Phone: 0300 123 6780
Email: developeras@lancashire.gov.uk
Your ref: 3/2025/0373
Our ref: 3/2025/0373/HDC/KW
Date: 30 May 2025

Location: Ethos House 4 York Street Clitheroe BB7 2DH
Proposal: Advertisement consent for 1 fascia sign and 1 double sided illuminated projecting sign to the front elevation.
Grid Ref: 374457 441950

Double sided illuminated projecting sign

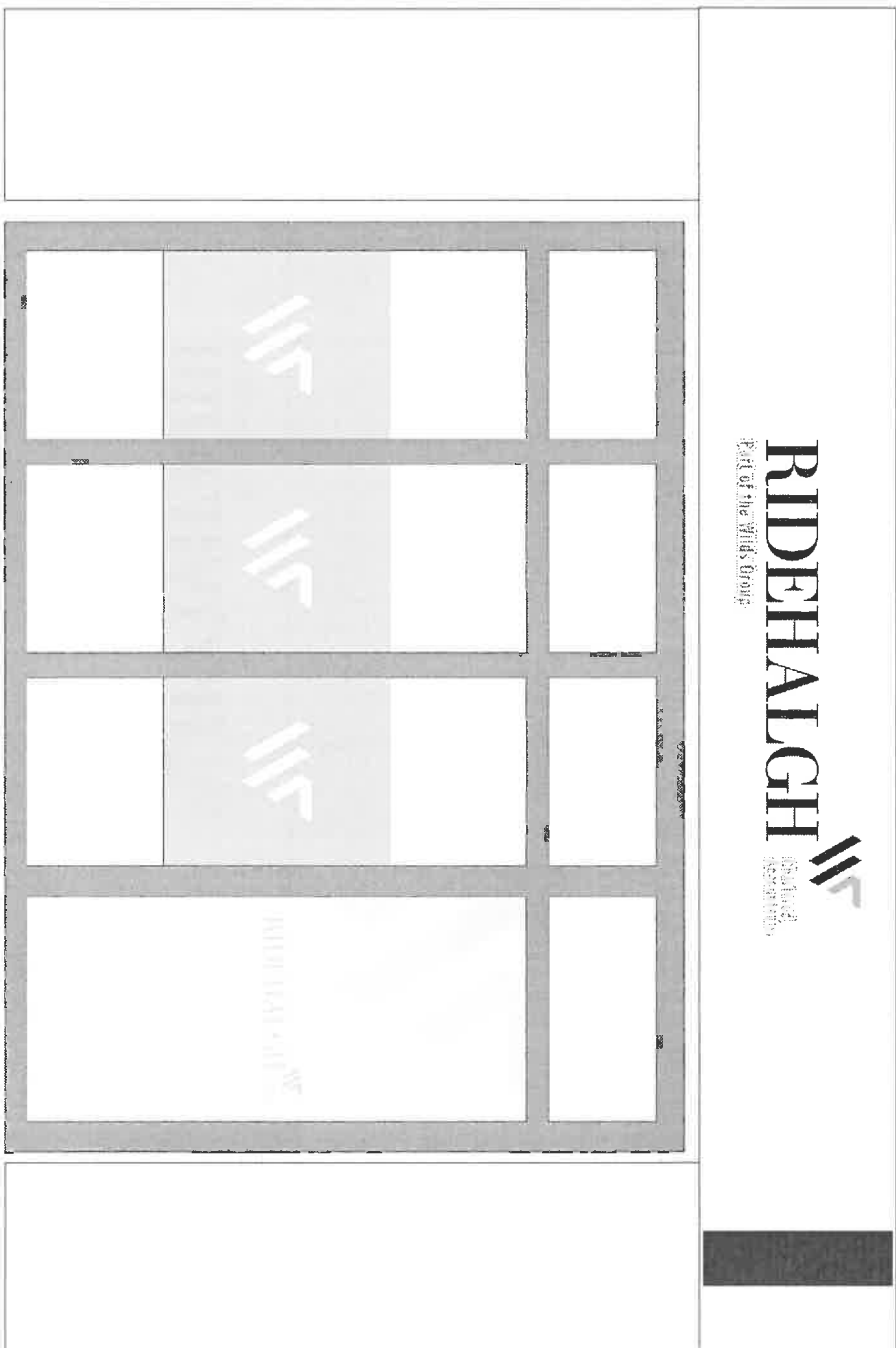
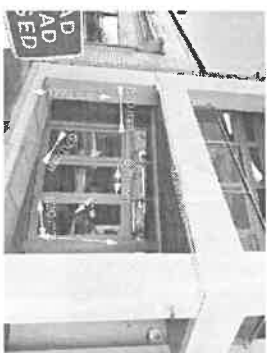
Lancashire County Council acting as the Local Highway Authority does not raise an objection in principle to the proposed development however the application form states that the projecting signage will be between 2.6m and 3.2m above ground level however this must be at least 2.7m above the carriageway level as is conditioned below. The applicant will be required to obtain a licence under Section 177 of the Highways Act 1980 from the Highway Authority to place the projecting signage over the highway.

- It does not obscure or hinder the ready interpretation of any traffic sign or signal.
- It does not hinder the operation of any device used for the purpose of collecting traffic data or measuring the speed of any vehicle.
- It does not create dazzle or distraction to motorist through the use of reflectorized materials.
- It does not have any section overhang the adopted highway; or alternatively
- Has a minimum clearance of 2.7 metres above the level of the adjoining footway and a minimum distance of 0.45 metres to the carriageway edge.
